Your ref:
Our ref: 21/01993/F
Please ask for: Mrs Rebecca Bush
Direct dial: 01553 616825
Direct fax: 01553 616652
E-mail: borough.planning@west-norfolk.gov.uk

Details: **Demolition of existing side extensions. Construction of 2 storey side extension and single storey front porch at Lumbertubs 7 Wheatley Drive North Wootton King's Lynn Norfolk**

PROPOSED BLOCK PLAN
SCALE 1:500 AT A1

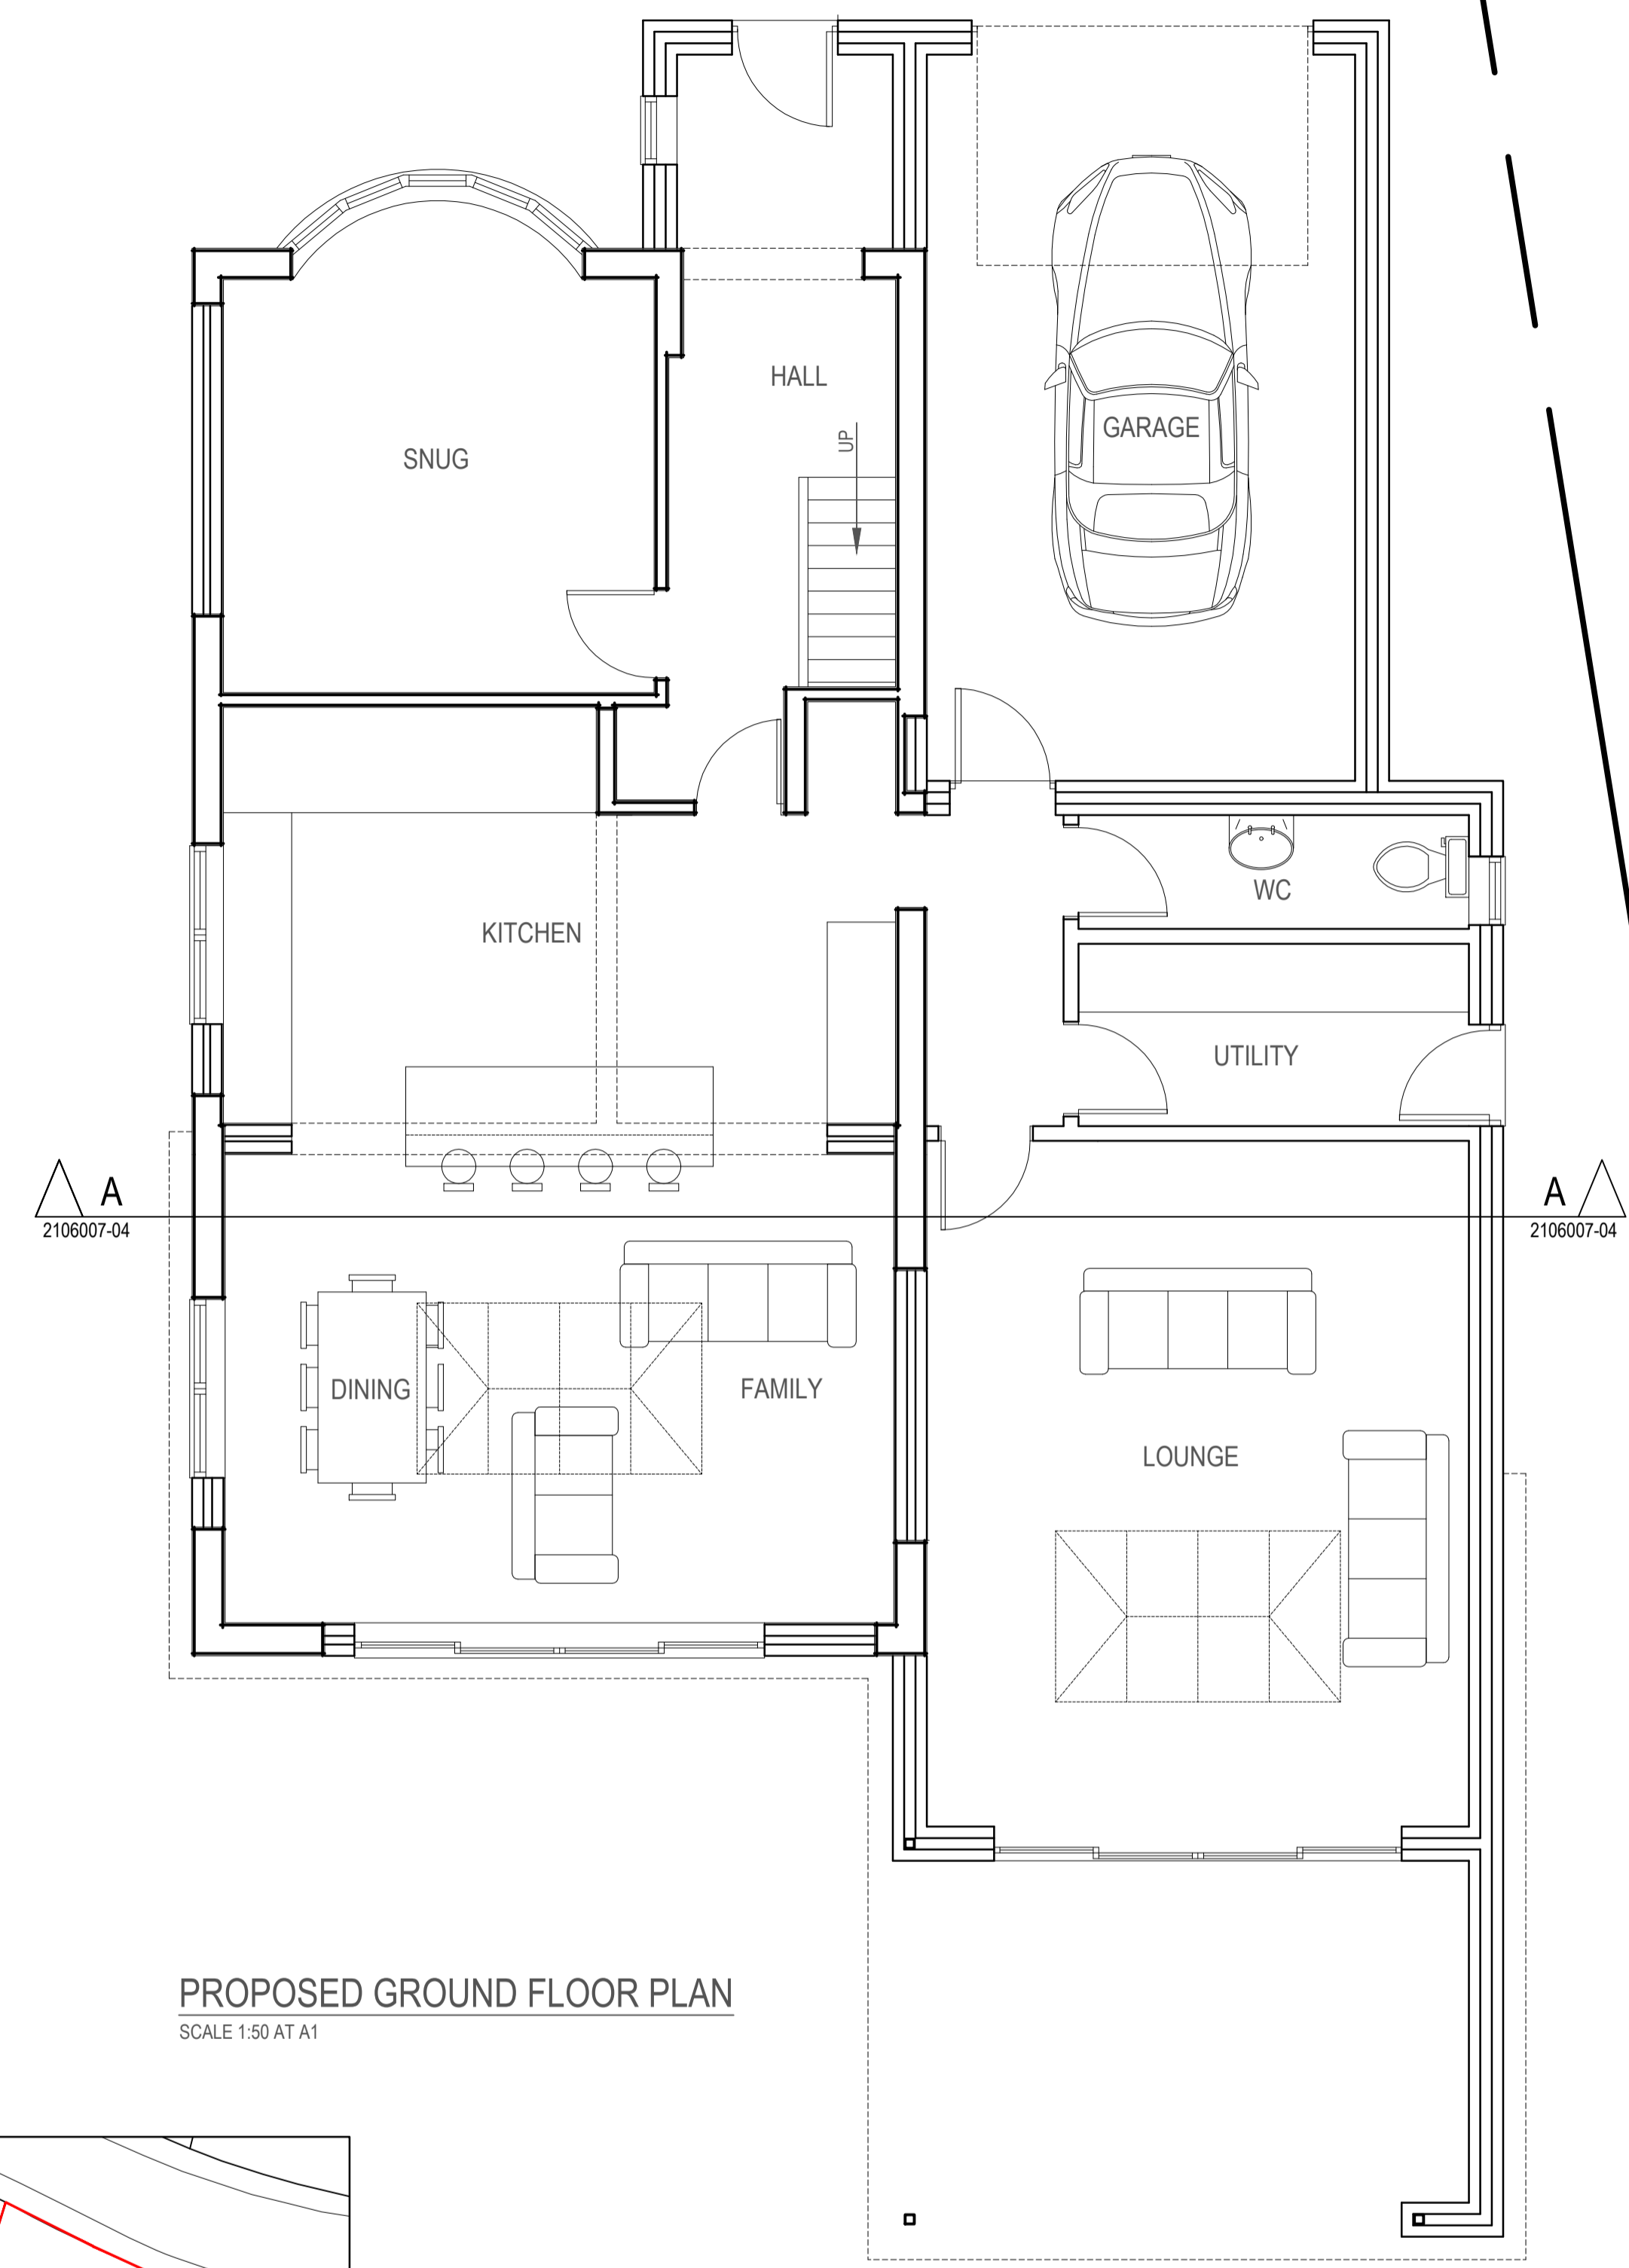
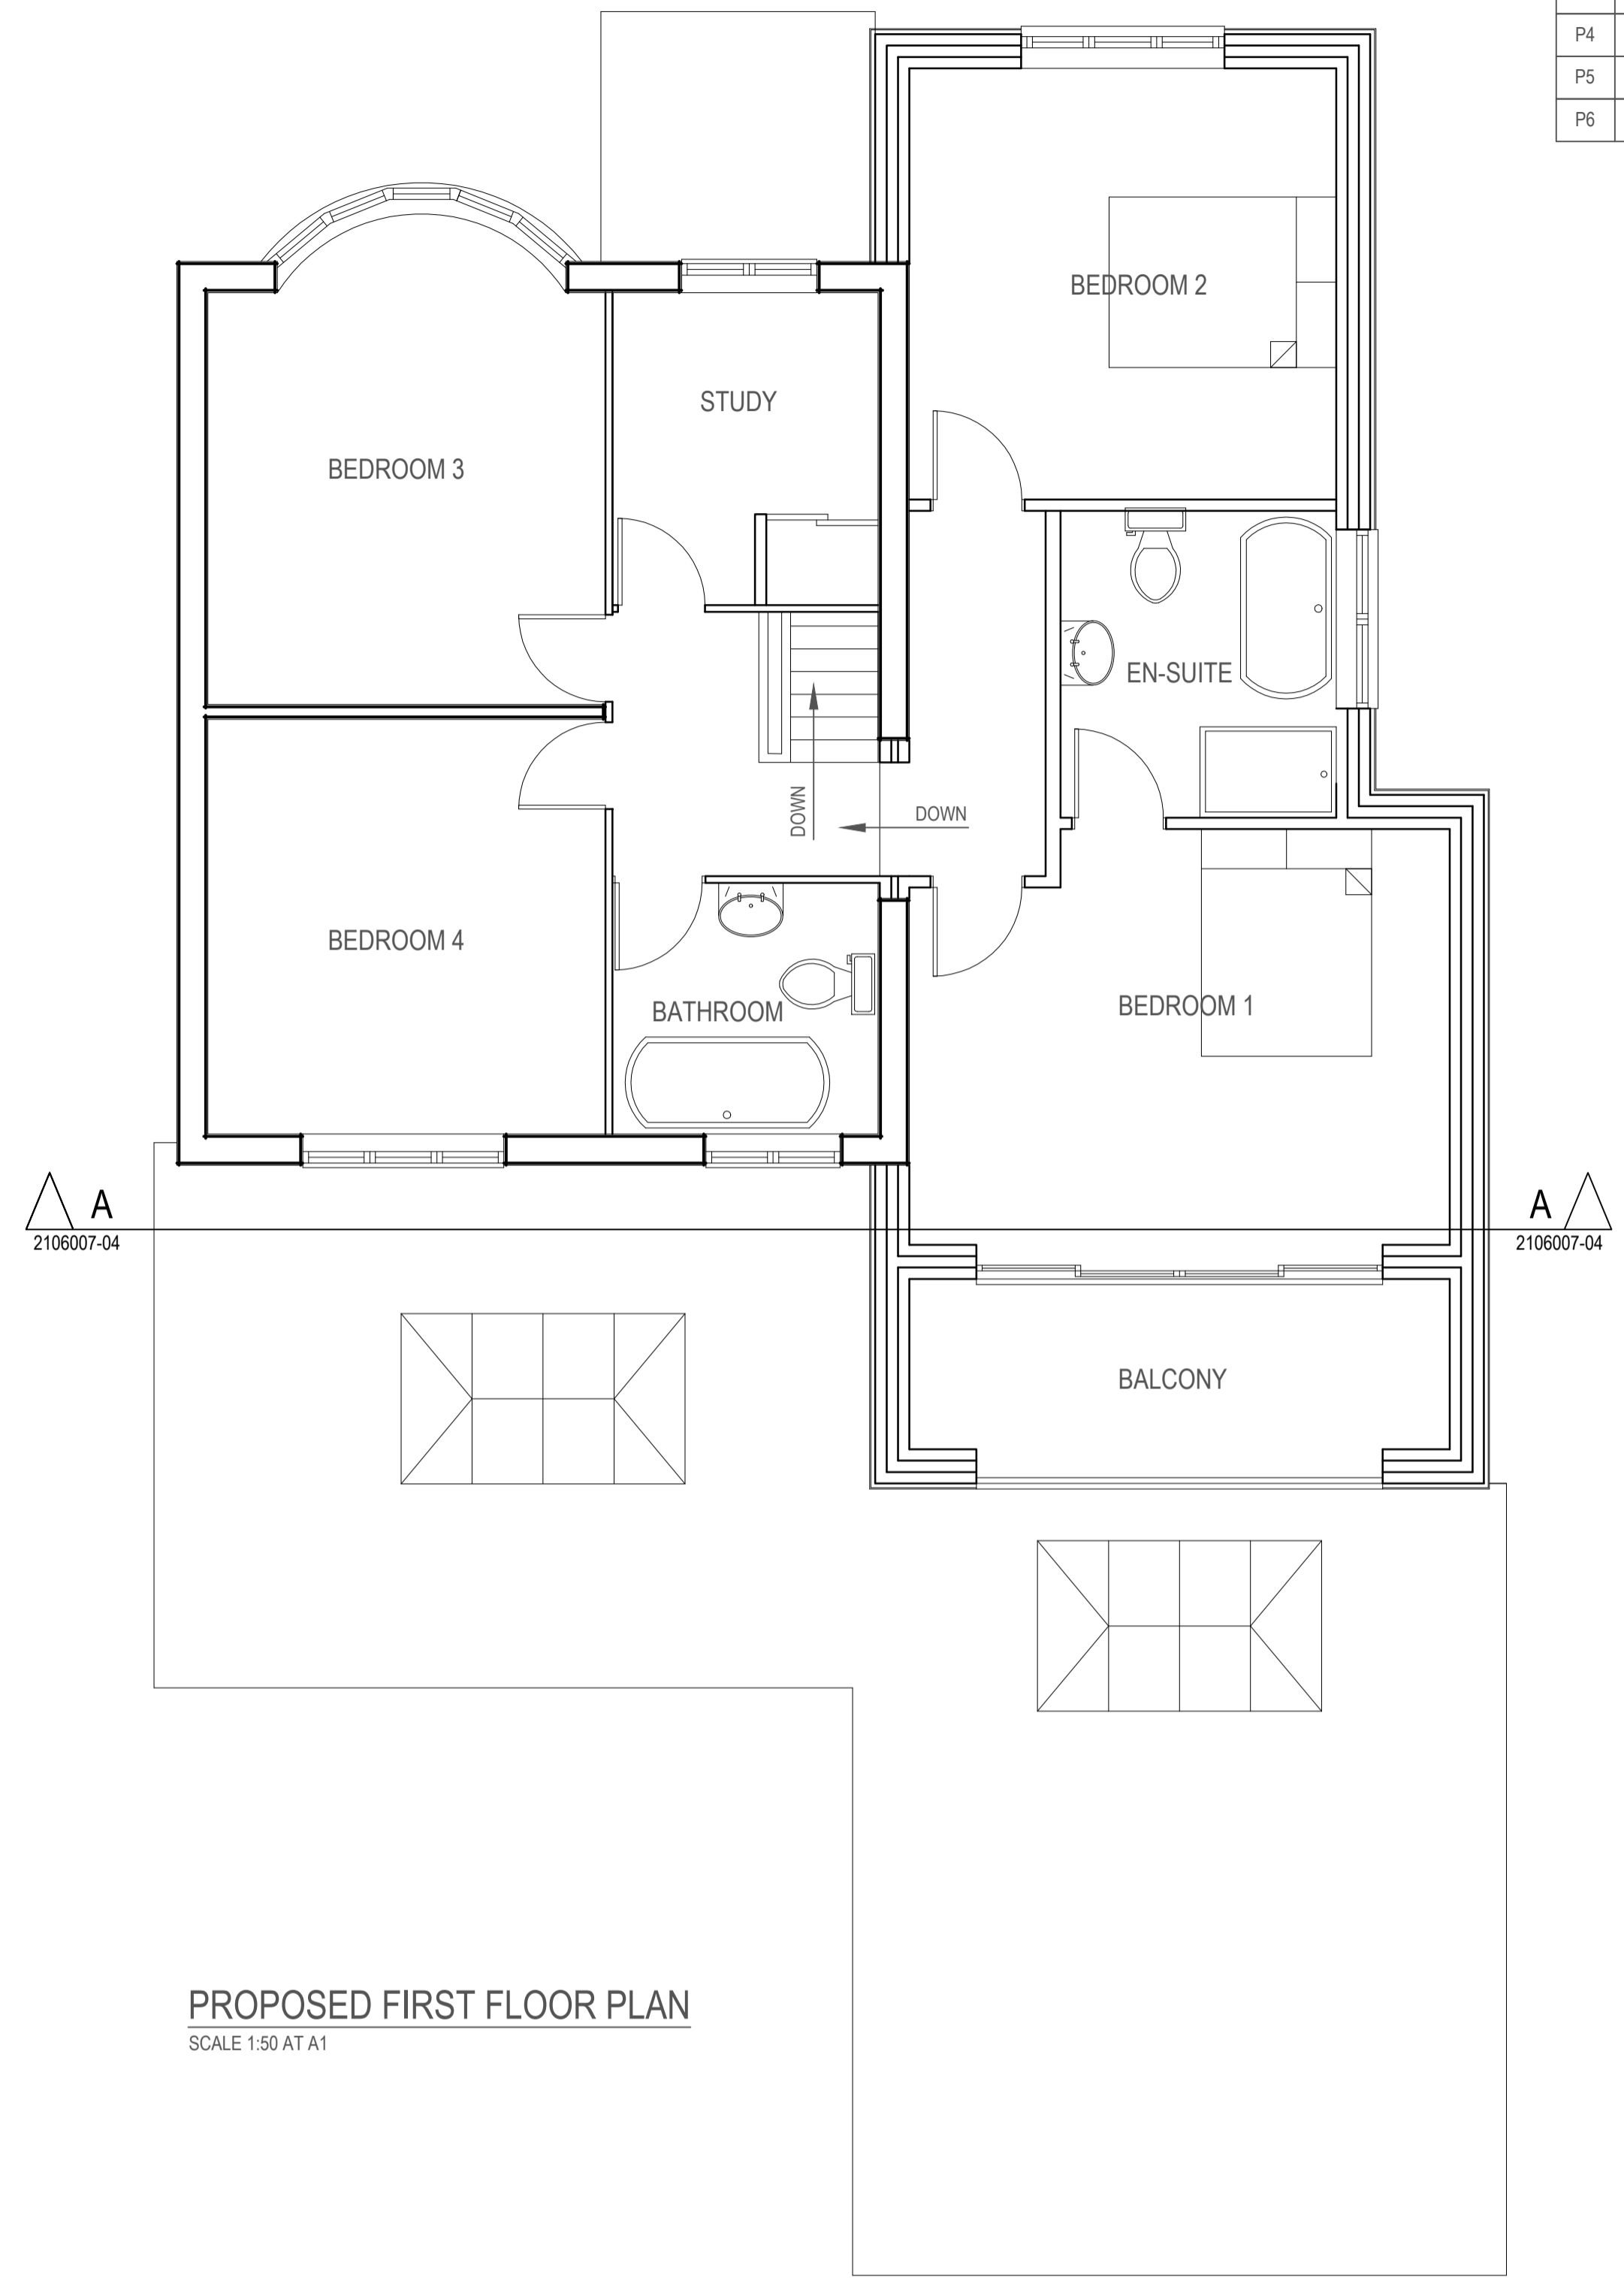
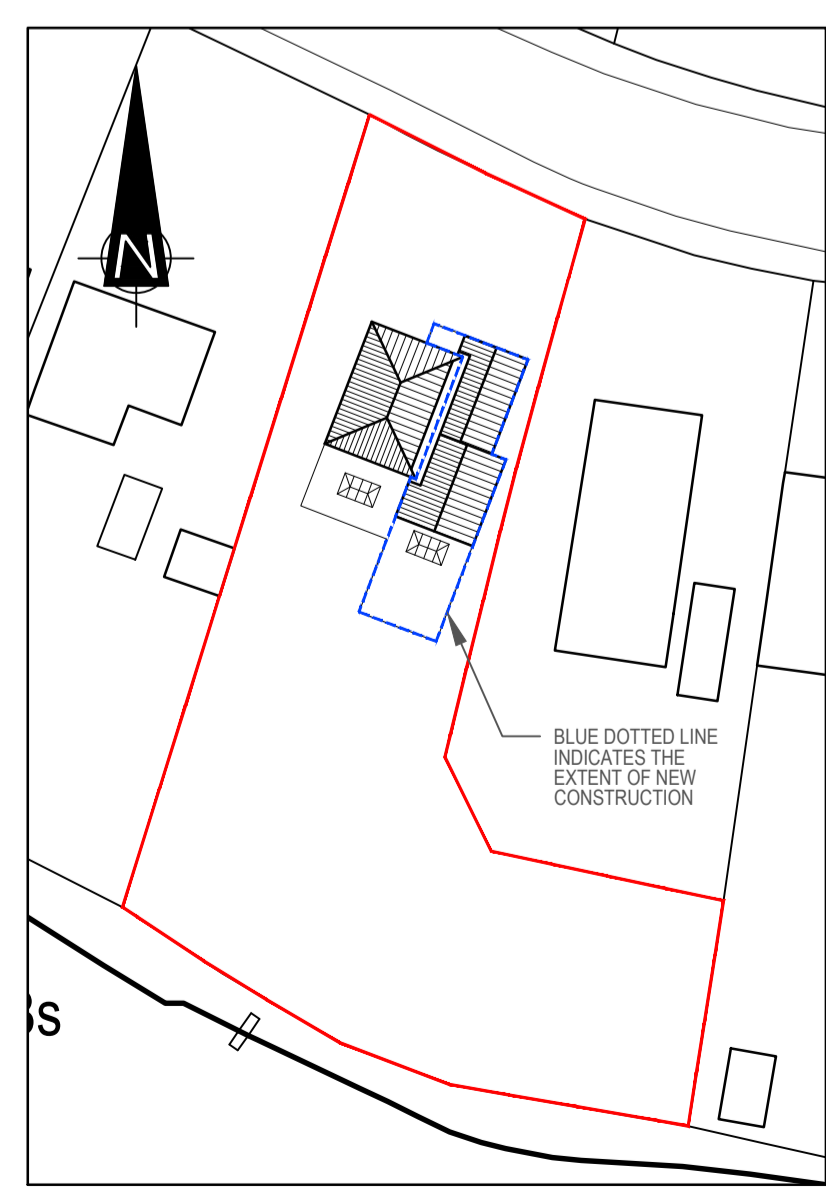
1. We will require a block plan/roof plan to a scale of 1:500 or 1:200 showing site boundaries and the new work.
2. Please provide four copies of a drawing, to a recognisable scale, showing a section through the new extension.
3. In accordance with the National Validation Checklist, which became mandatory on 6 May 2008, we will require information regarding site levels. If site levels are to change, please provide four copies of a site survey drawing, alternatively, if site levels are to remain unchanged, this can be annotated on the relevant plan or advised in writing.
4. As the property lies within an area at risk to flooding, please complete the simplified Matrix and return it. The Matrix can be found at https://www.west-norfolk.gov.uk/info/20173/information_for_planning_agents/231/flood_risk_information
